CLEAR VIEW INDUSTRIAL PARK, FILING 2A

GRADING, STORM AND EROSION CONTROL PLANS

PCD Filing No.:
CDR208

C:\Temp\CV\CAD\Grad\5 GRADING - Pond Details.dwg, 5/11/2020 10:58:10 AM, DWG To PDF.pc3

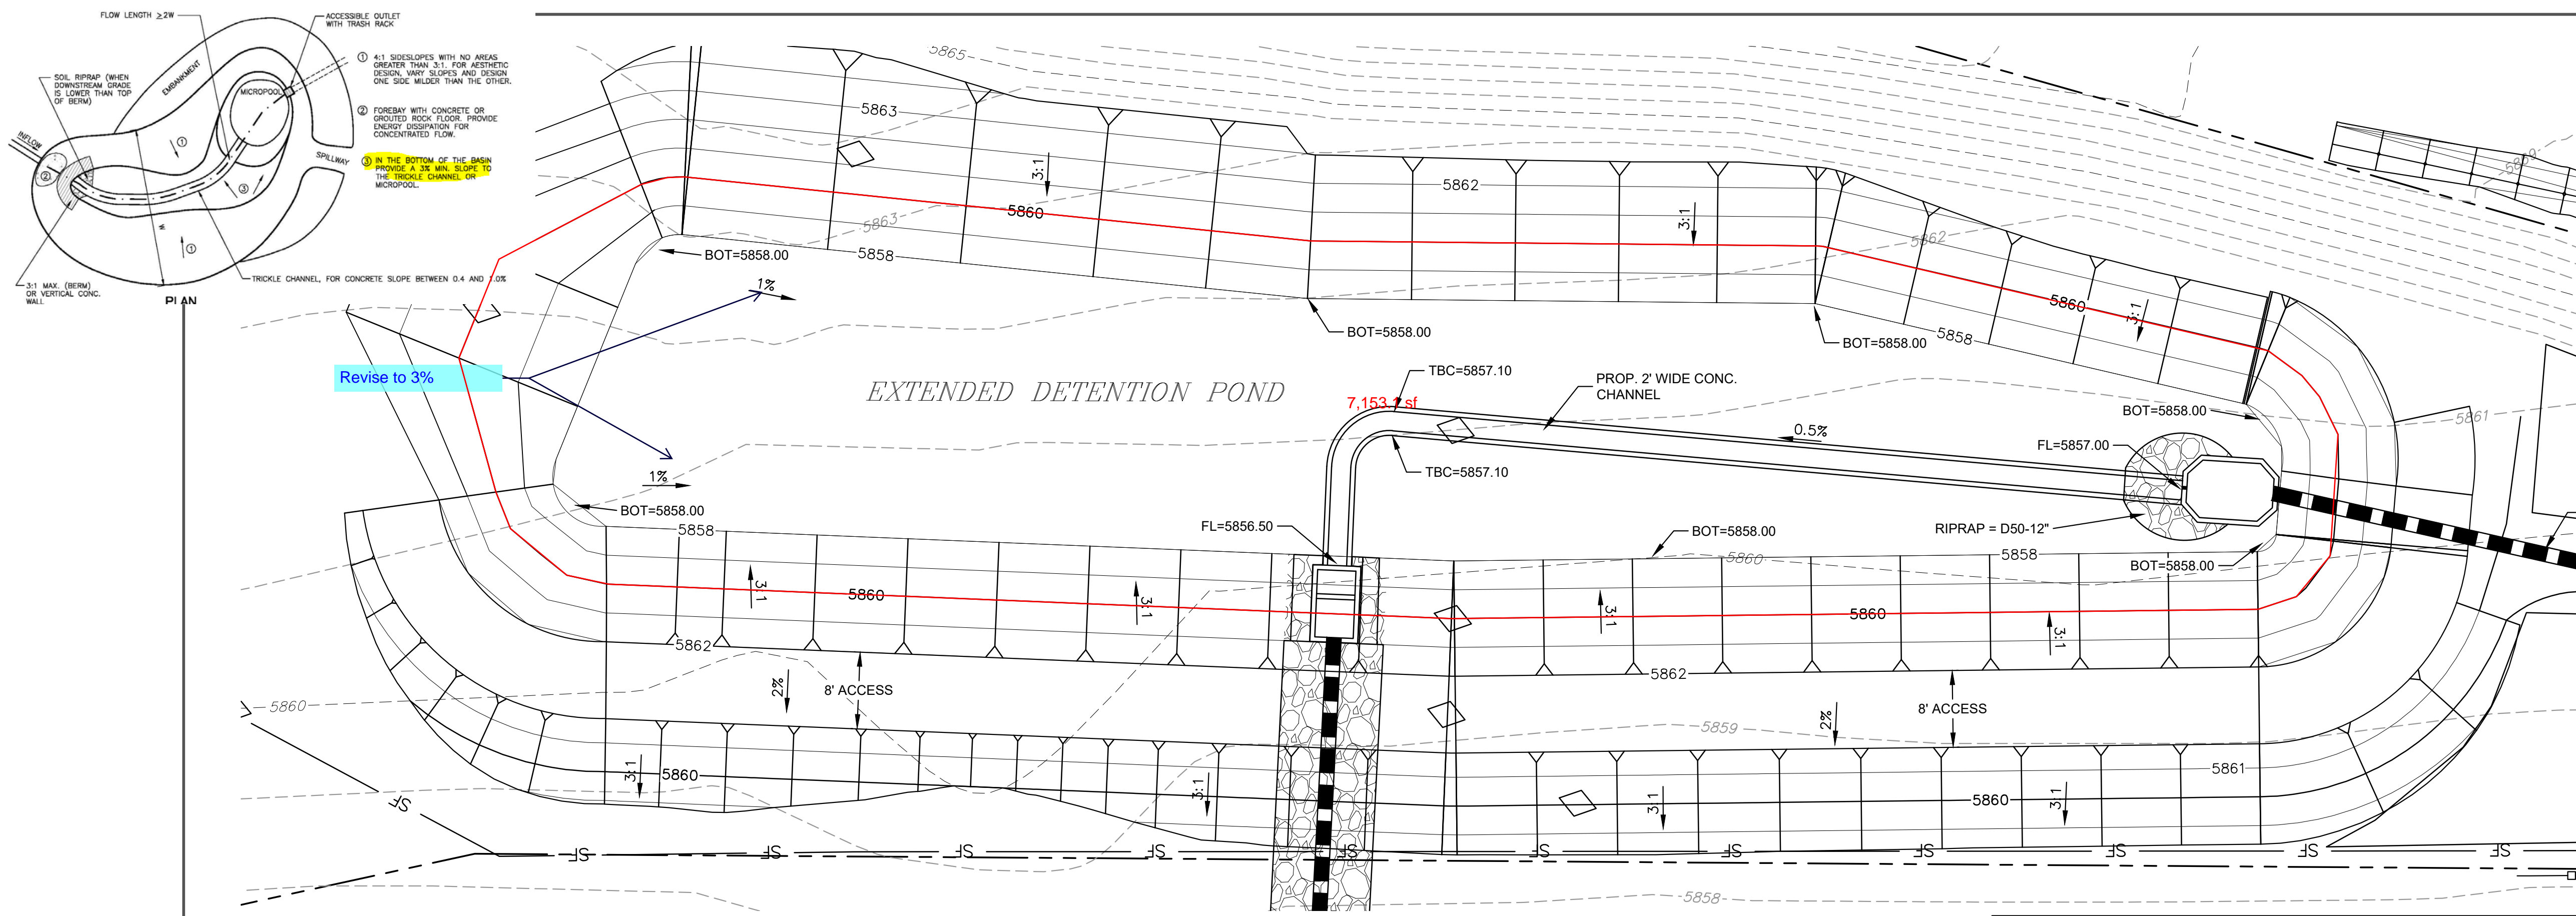
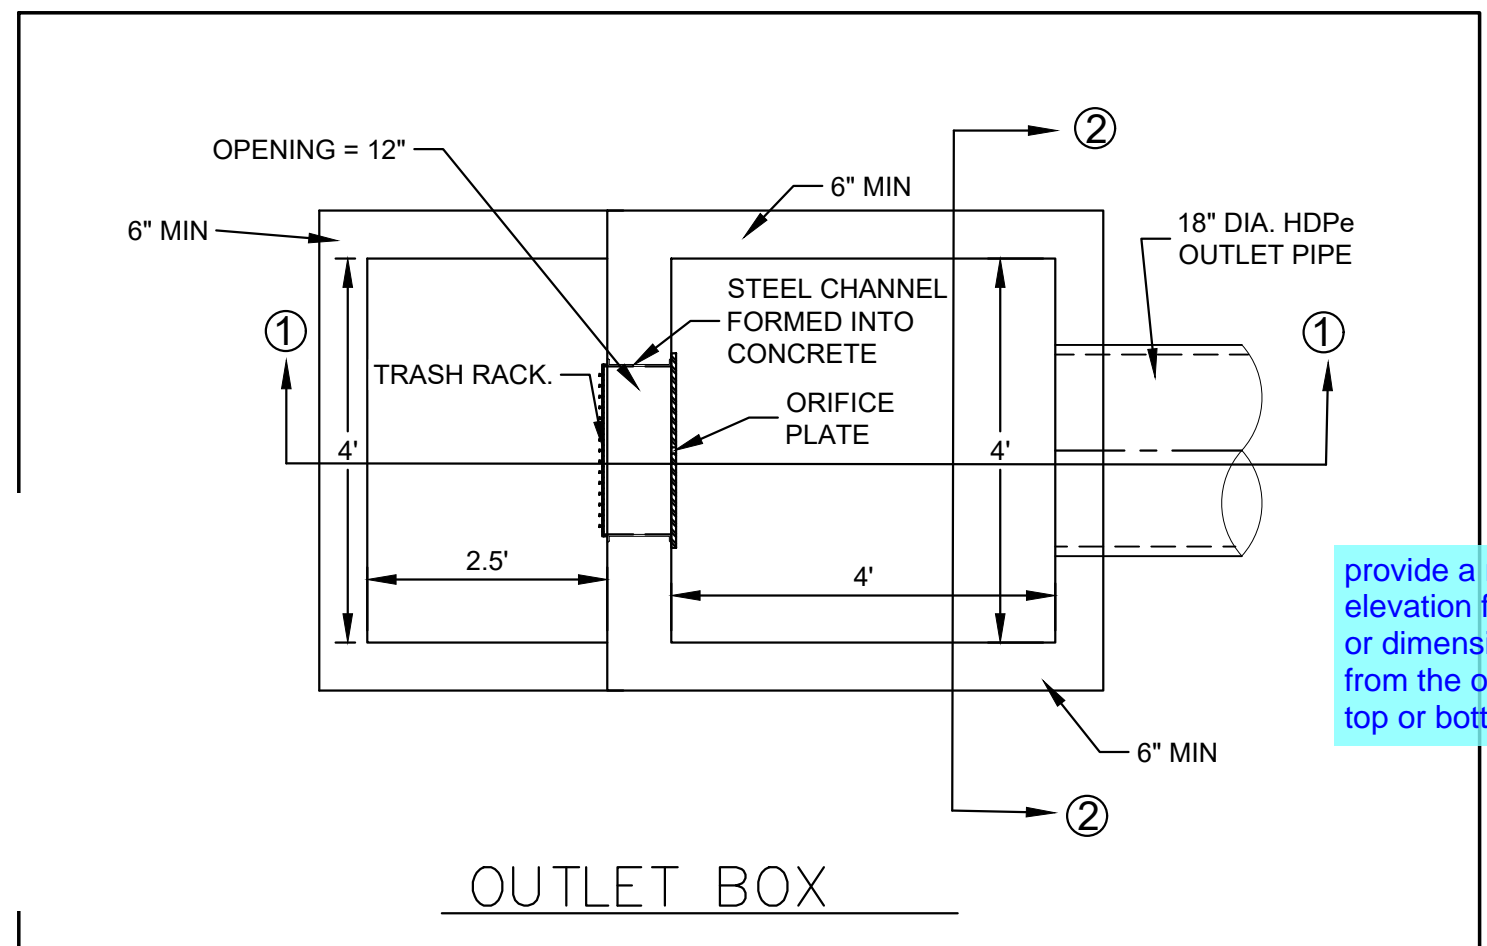
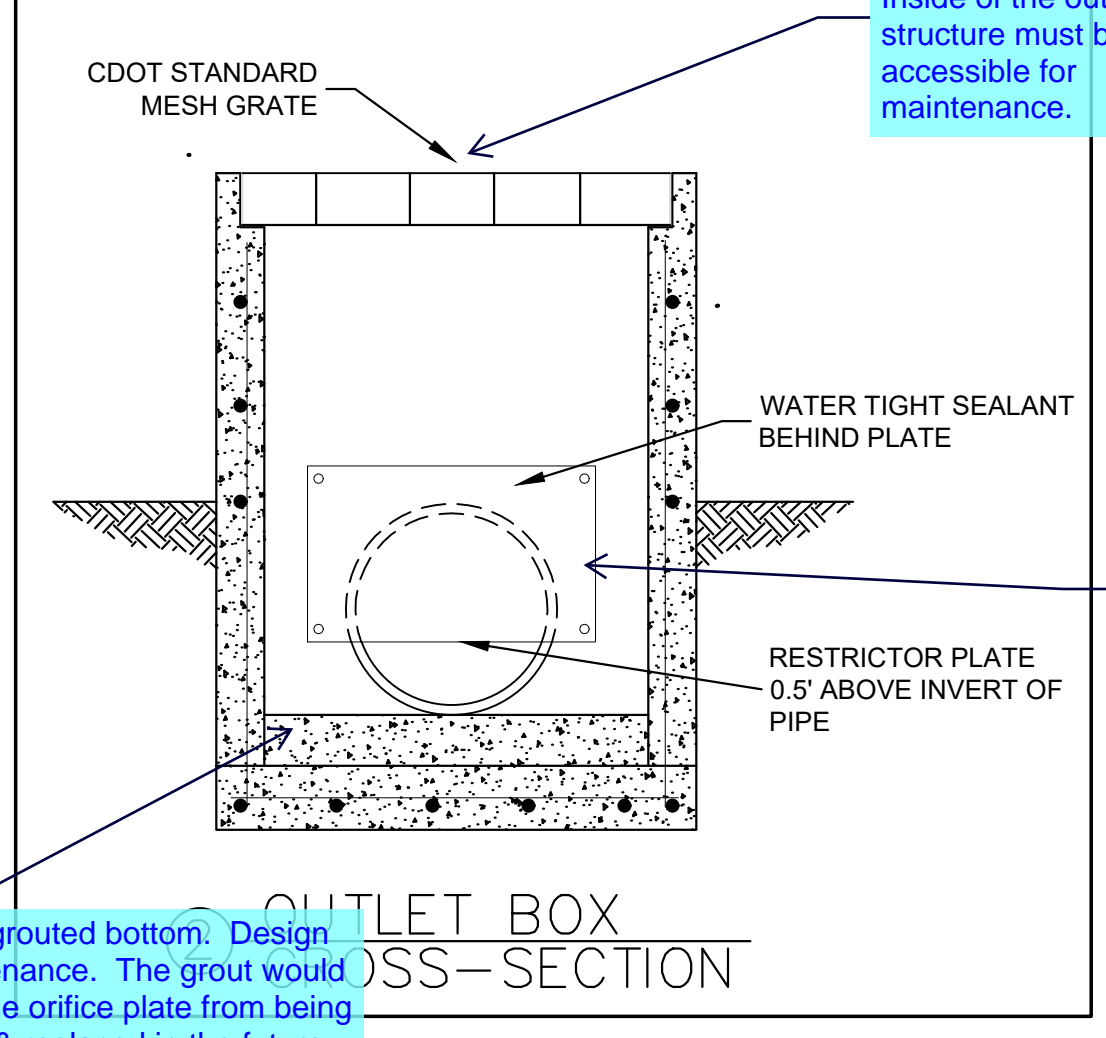
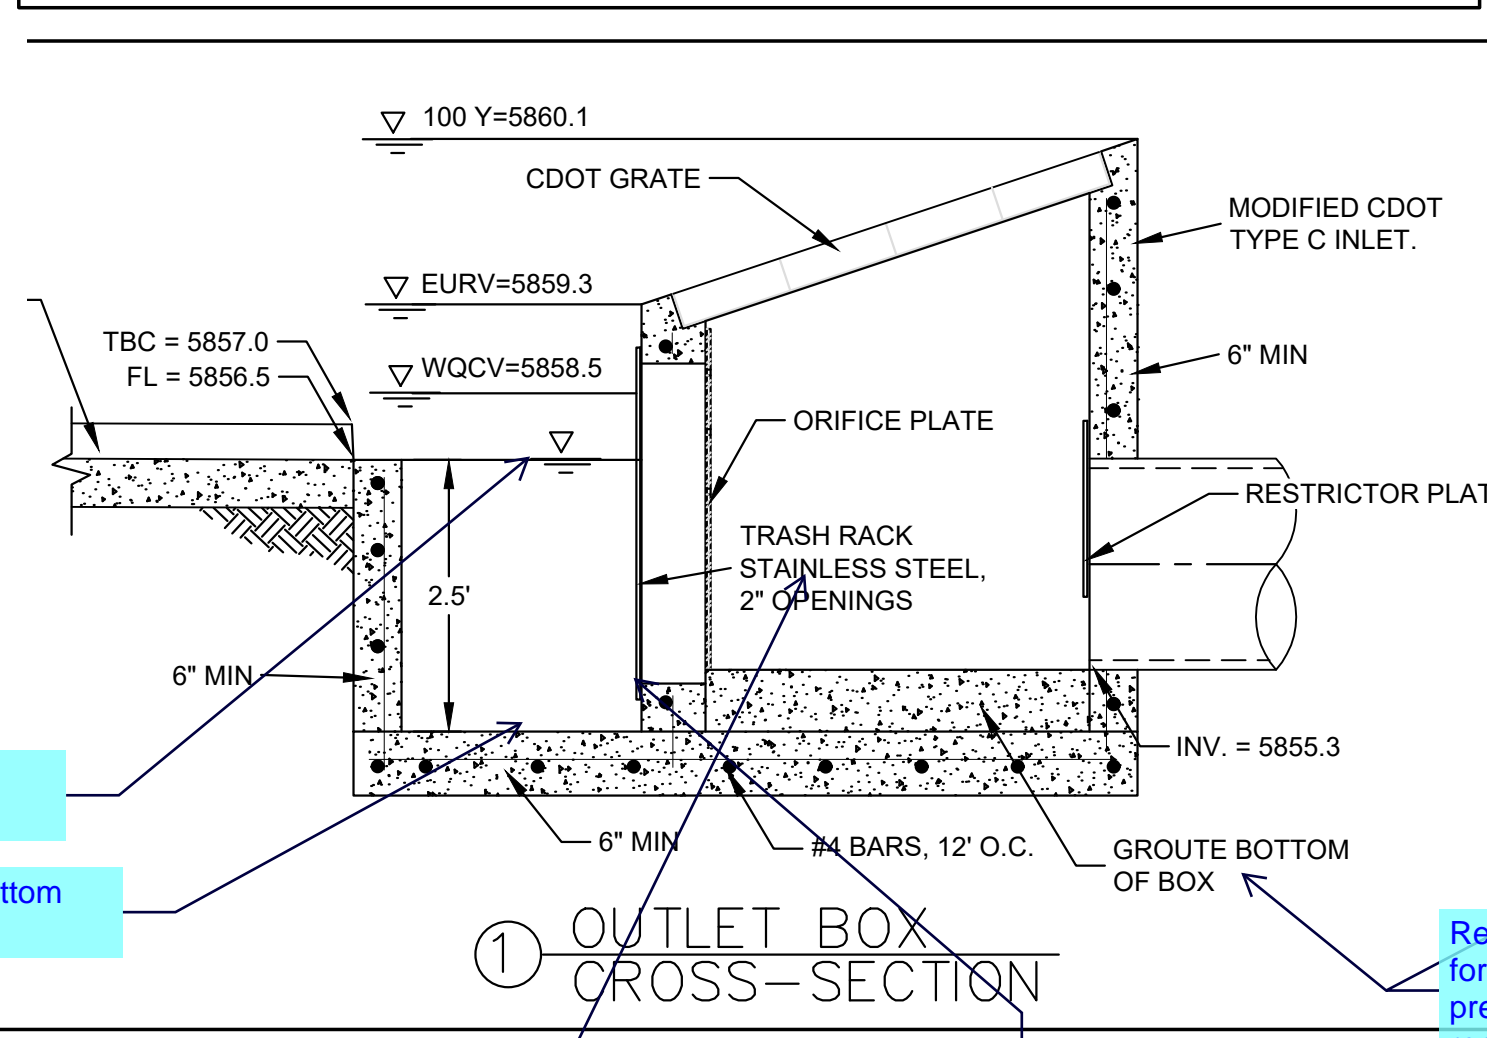
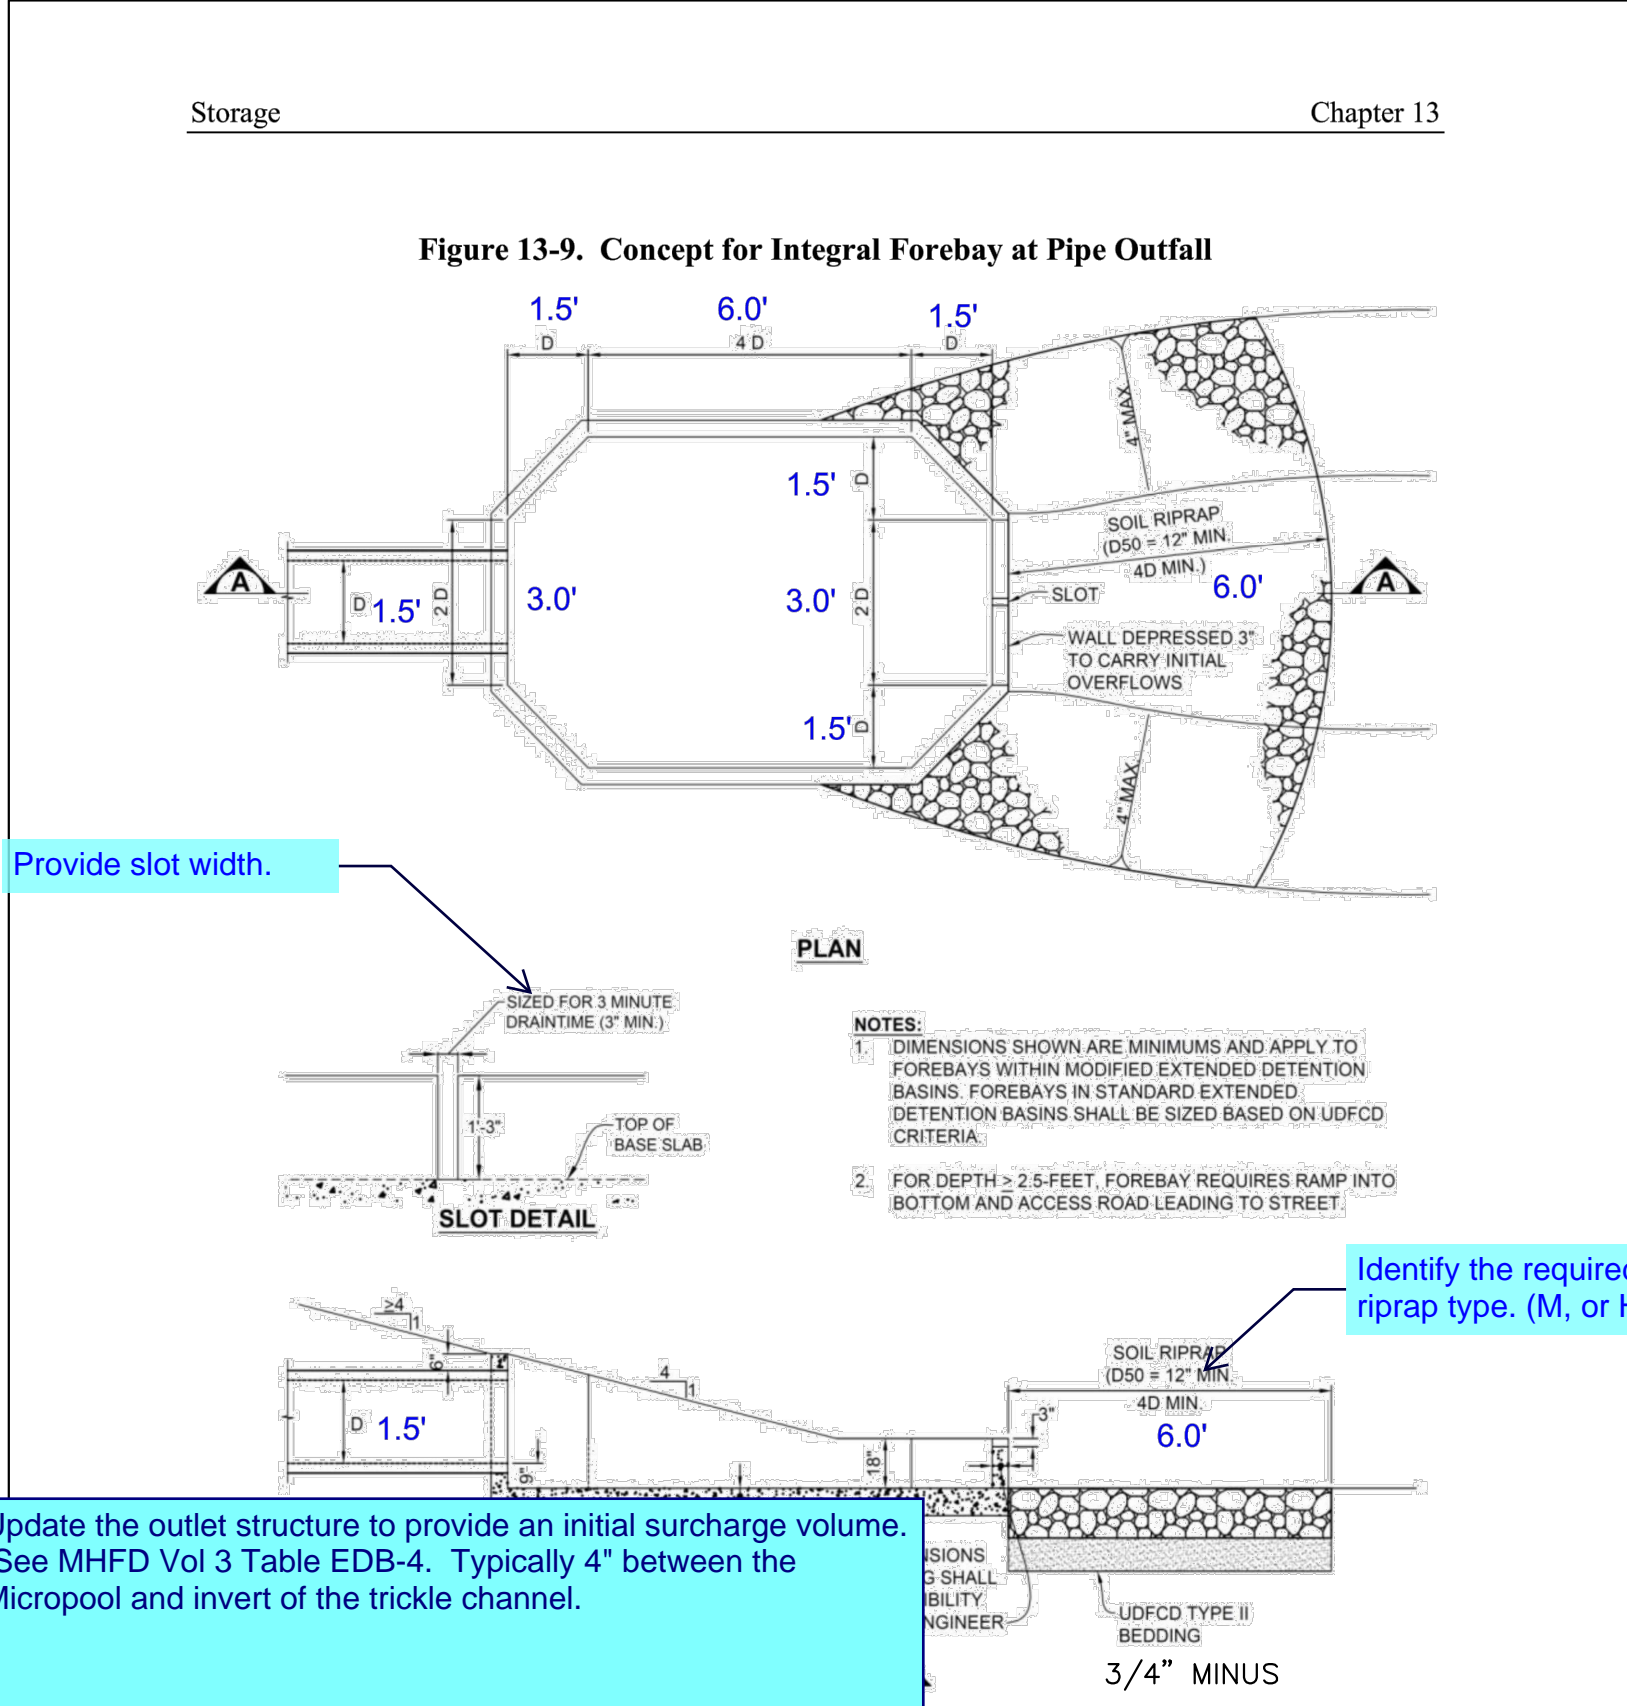
Can not verify orifice opening size and placement, calcs not attached to Drainage Report. Include in next submittal.
